From: Richard Smith [REDACTED]
Sent: 29 April 2021 11:16
To: Planning.Responses <Planning.Responses@arun.gov.uk>
Subject: Re: Please find attached acknowledgement of Planning Application Comment - R/61/21/CLP

Having reconsidered this application, R/61/21/CLP I would like to withdraw my previous submission, ref OWPC35455, and instead make the following representation.

PROPOSED PLAN 1:100

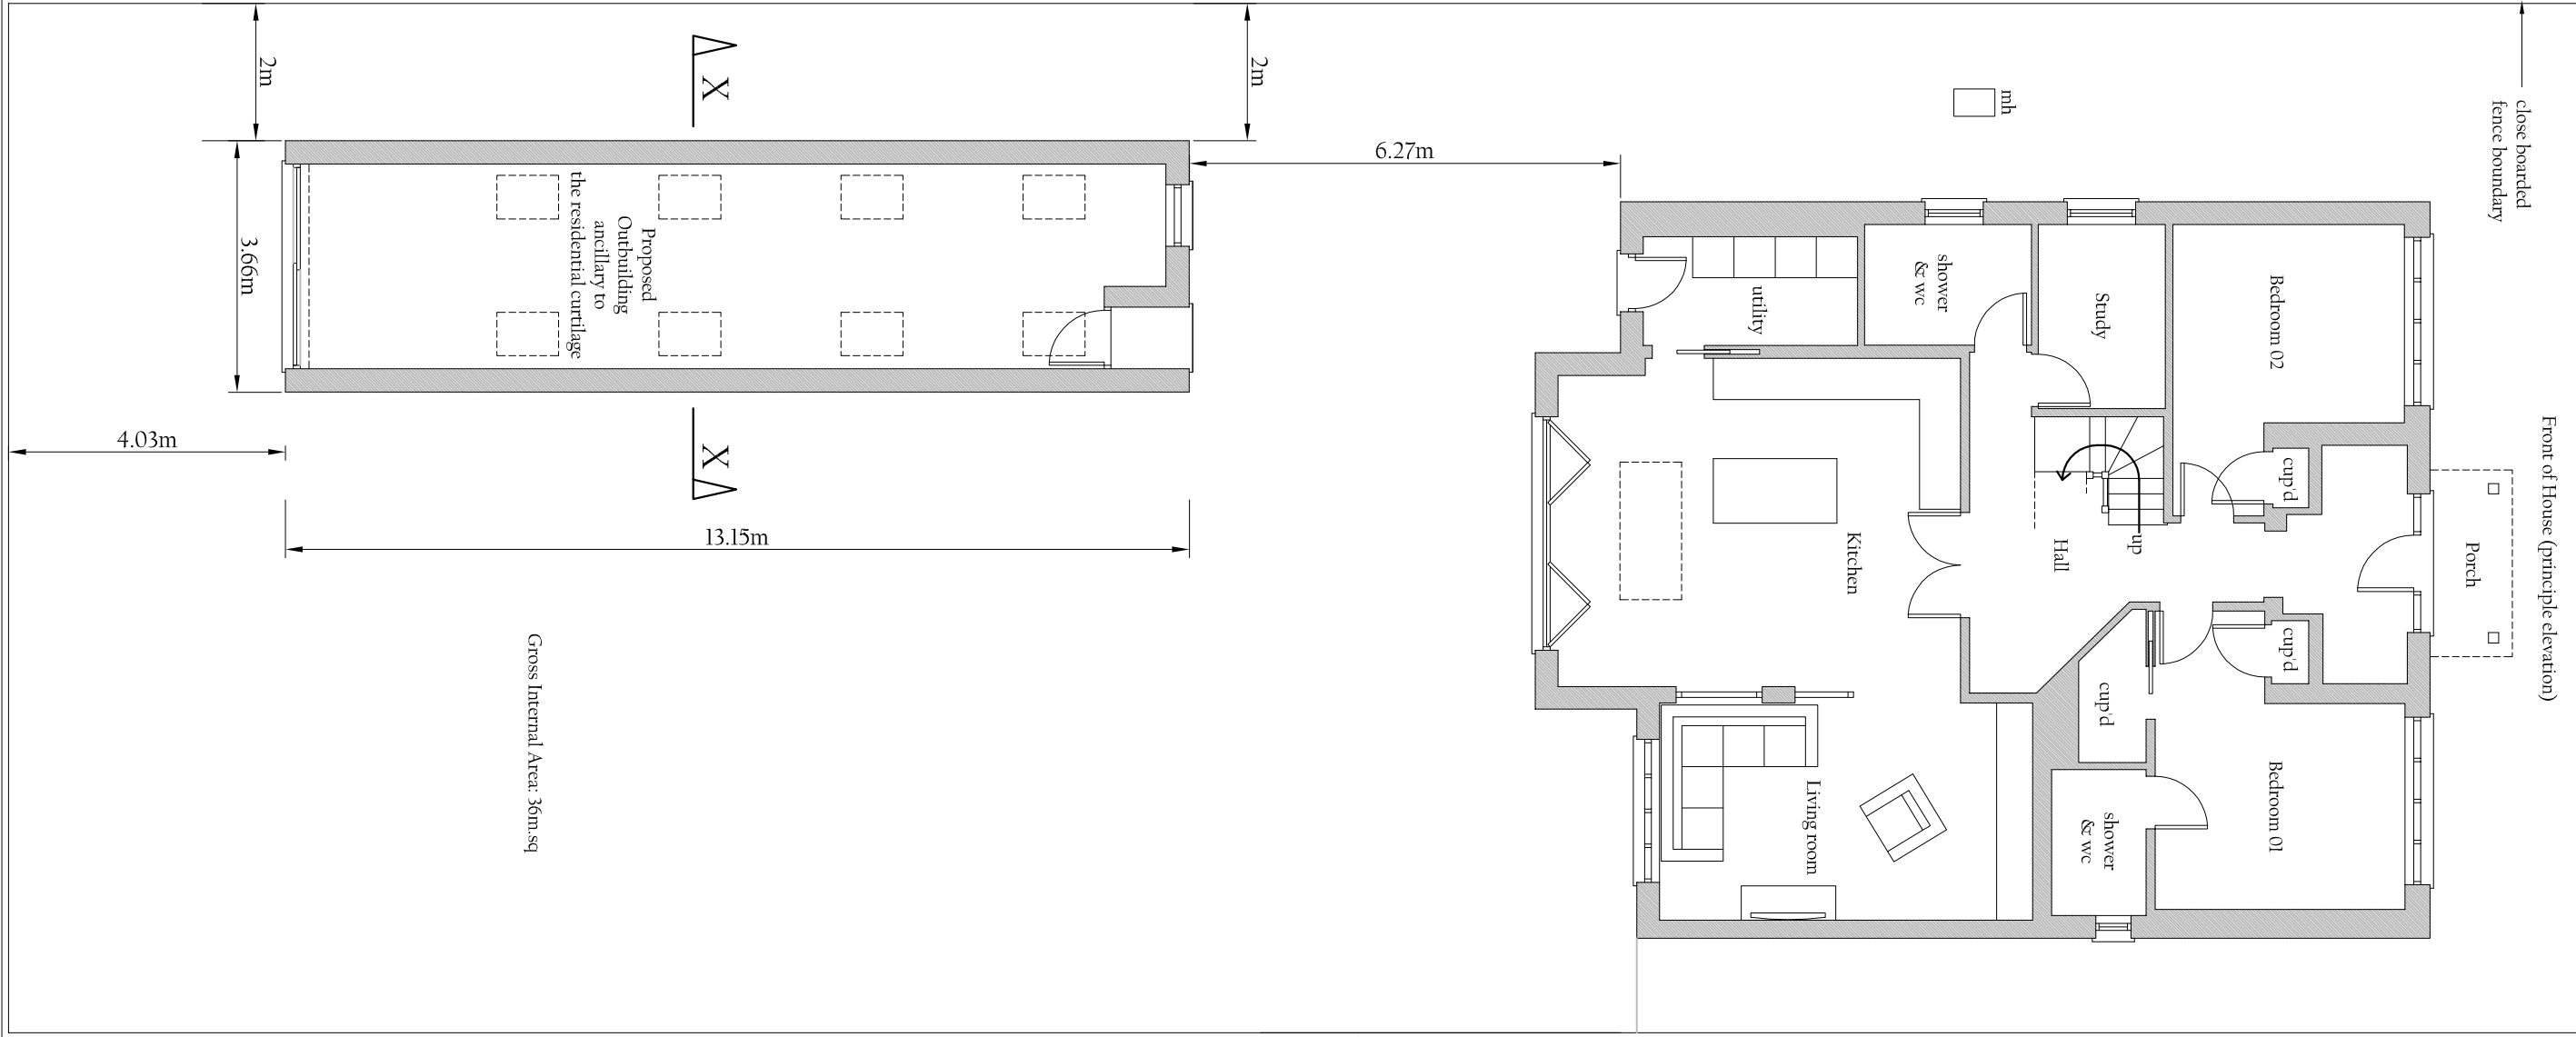
The revised development is slightly narrower and shown as being 1 metre further from the adjacent boundary. However the plans do not show the residential nature of the previous submission yet offer no indication of the intended use of the development.

The plans include an entrance door, possible patio doors at rear and windows including 8 apex windows that would fully support the use of the building for residential purposes. This would constitute a second and separate residential dwelling on a single plot.
